Project #: 1005251

Project Name: PARIS ADDITION

**CITY OF ALBUQUERQUE  
PLANNING DEPARTMENT  
February 19, 2014  
DRB Comments**

**RE: Lot A-1, Block 20 Paris Addition**

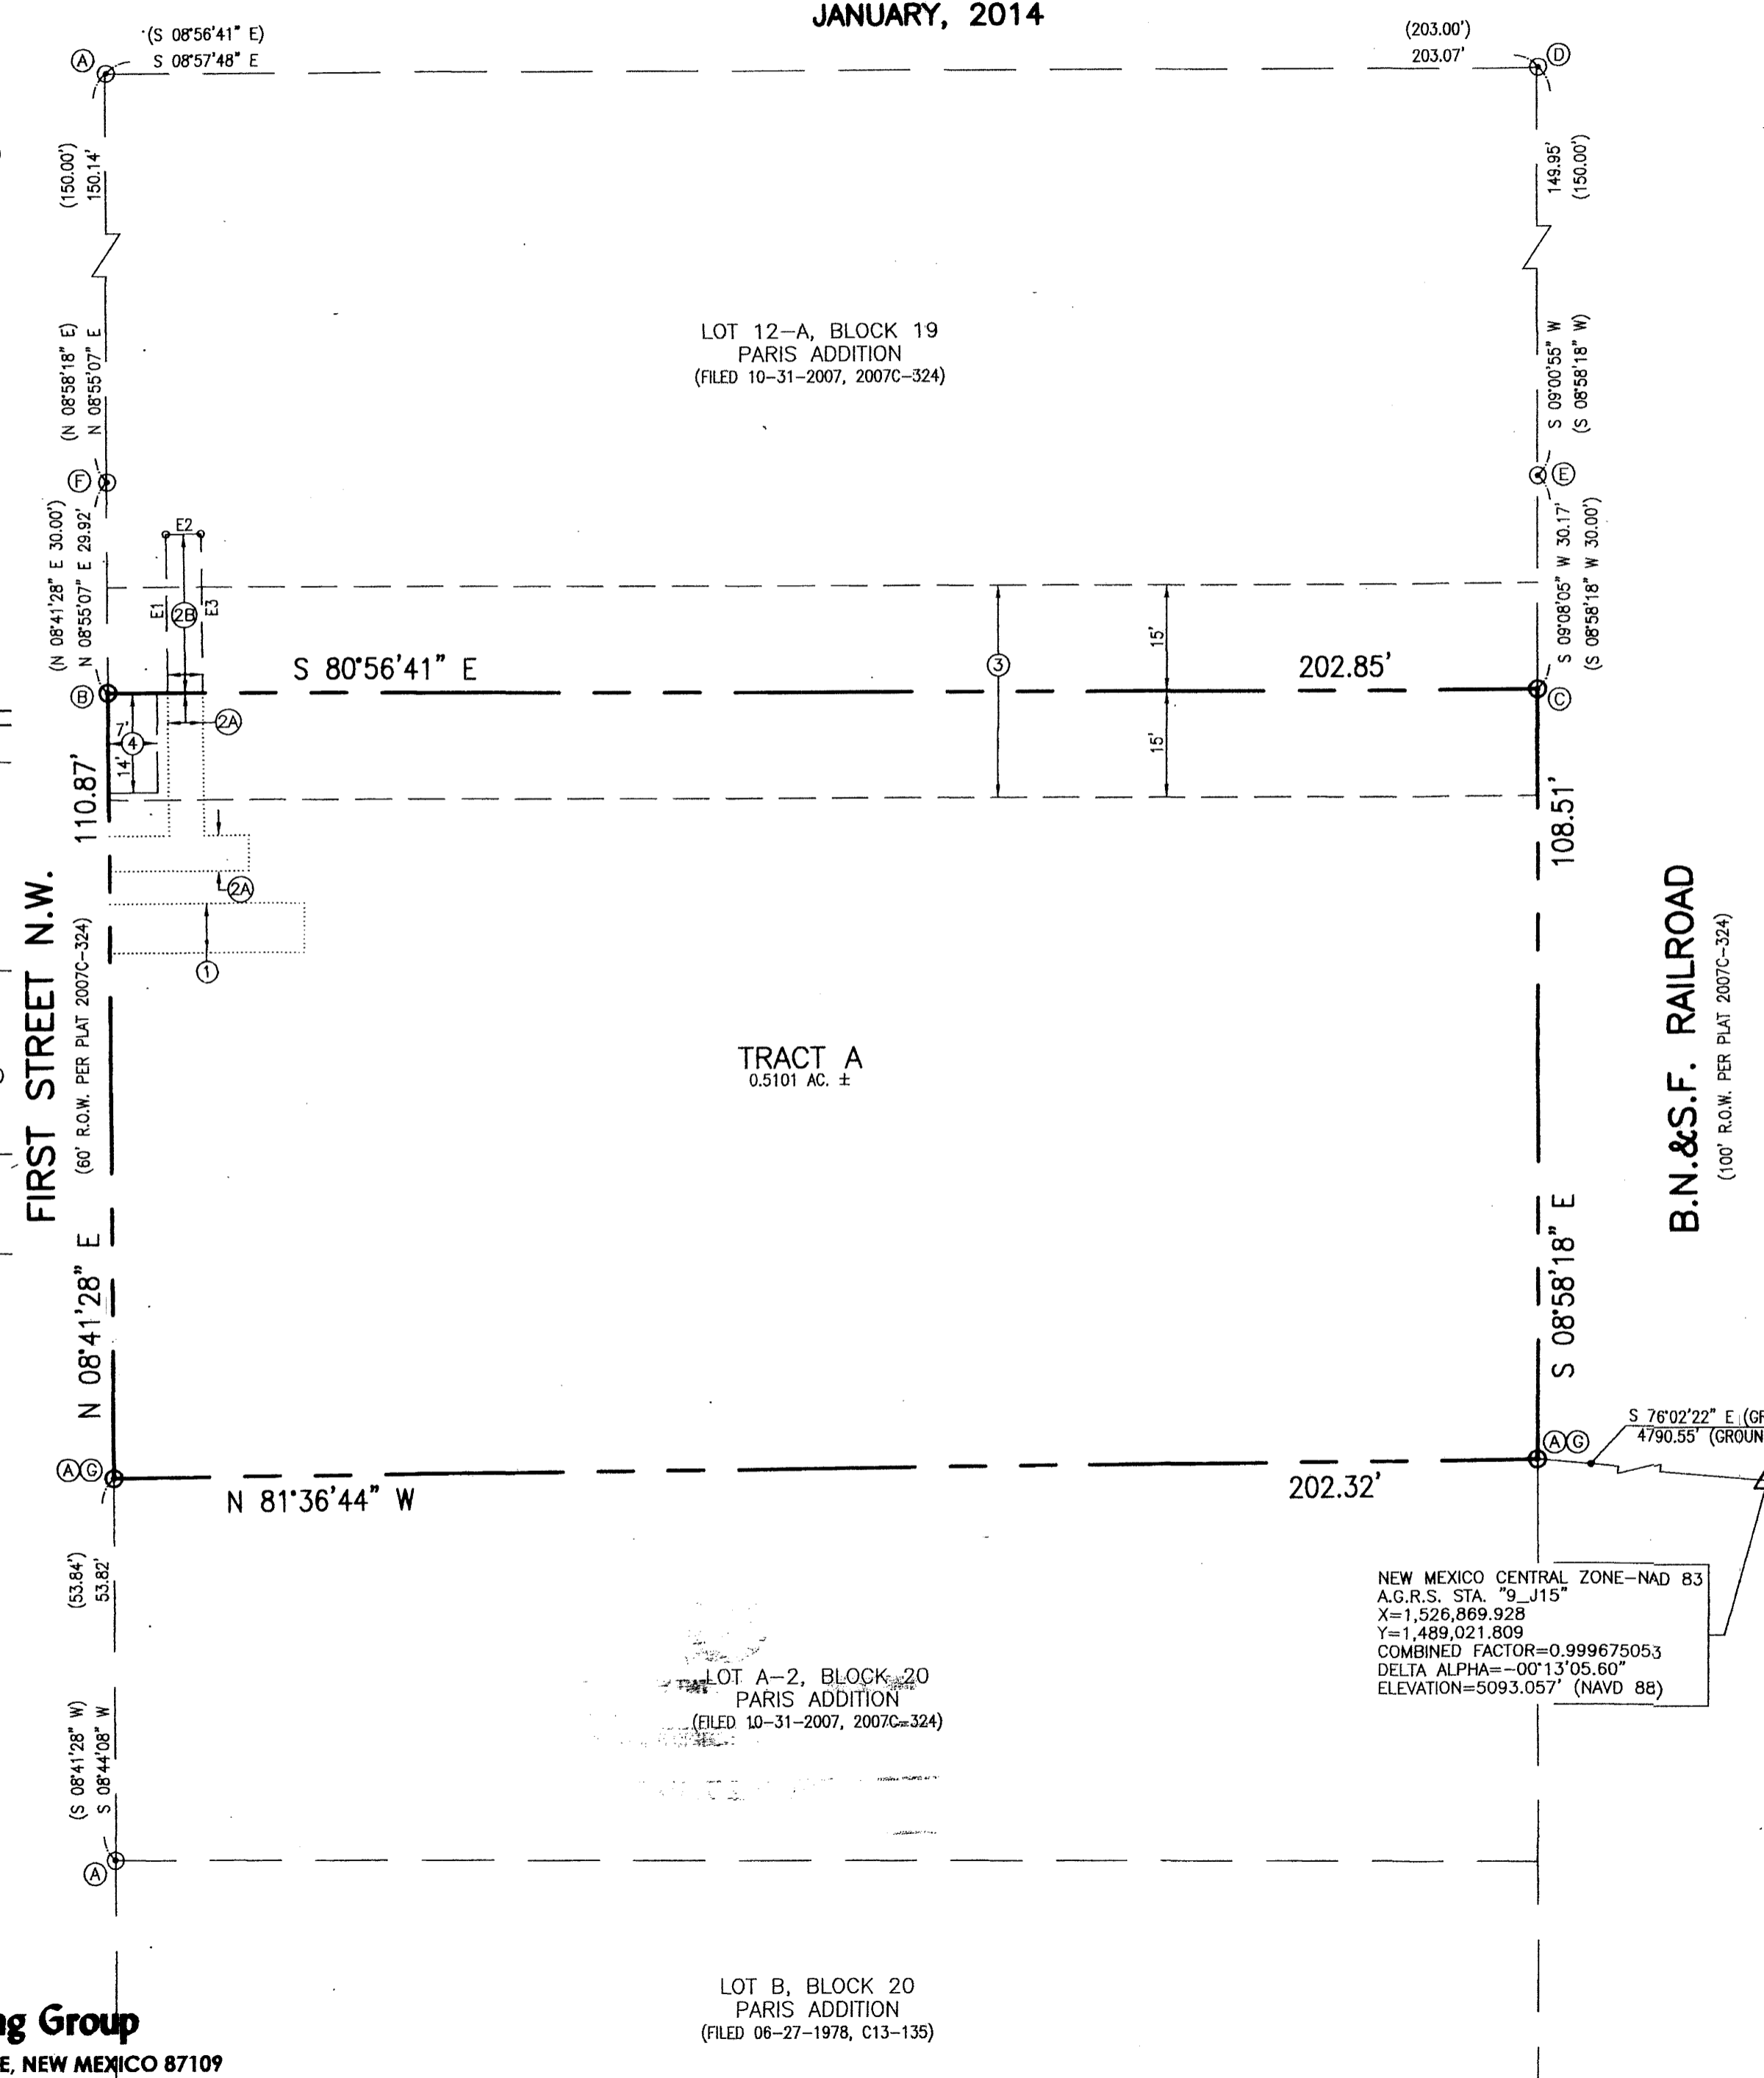
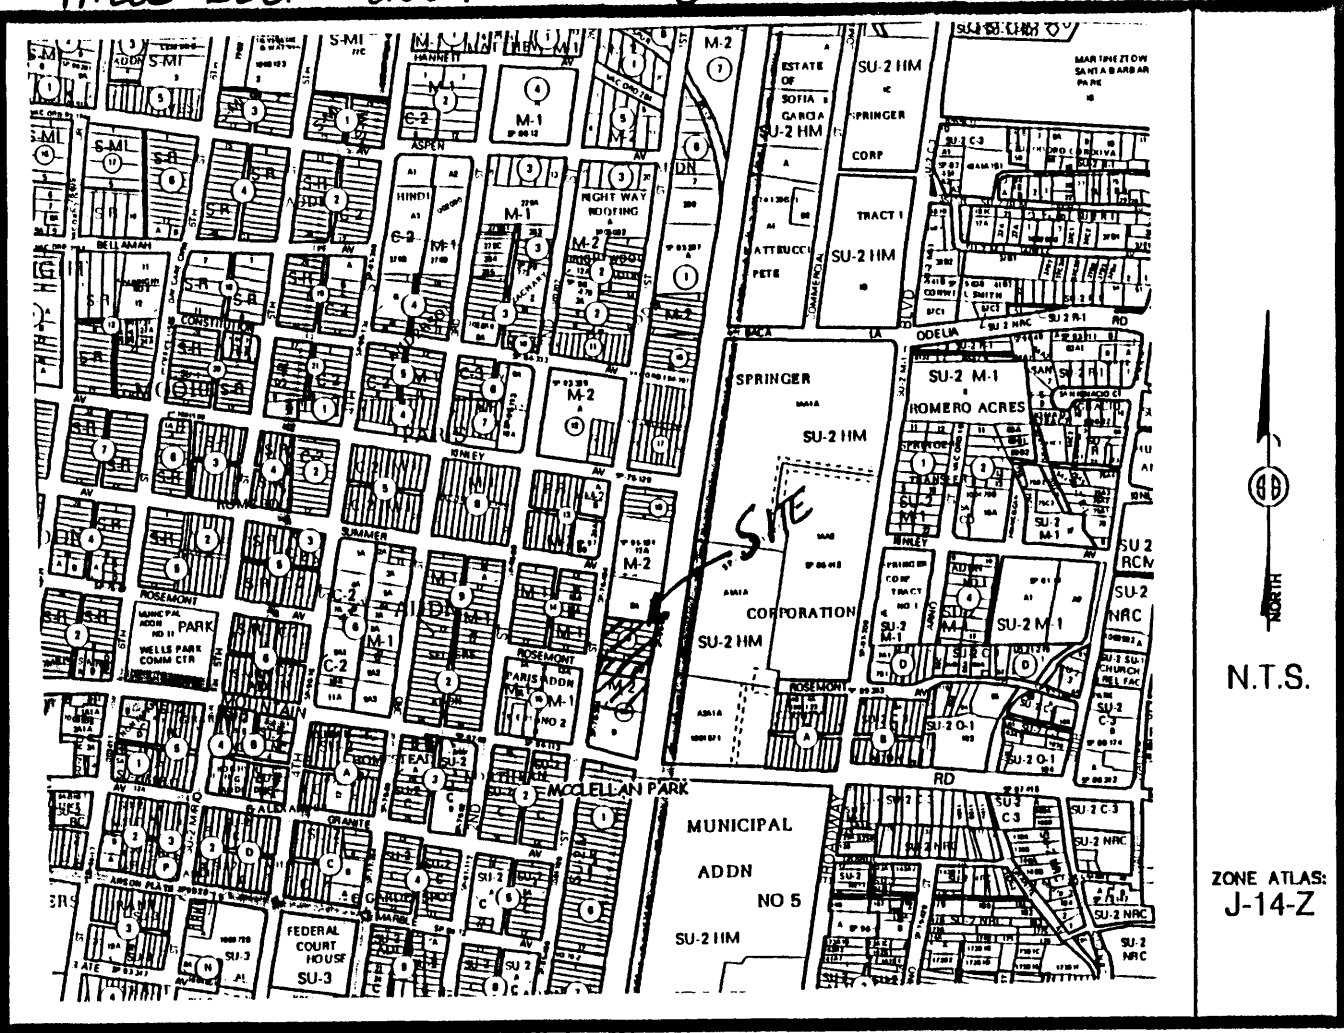
Based on the Subdivision Ordinance requirement for benefited parties to be clearly defined and in agreement to the proposed vacation, and given the Disclaimer on Sheet 1 of the plat, please provide written agreement from PNM and Gas Co of NM.
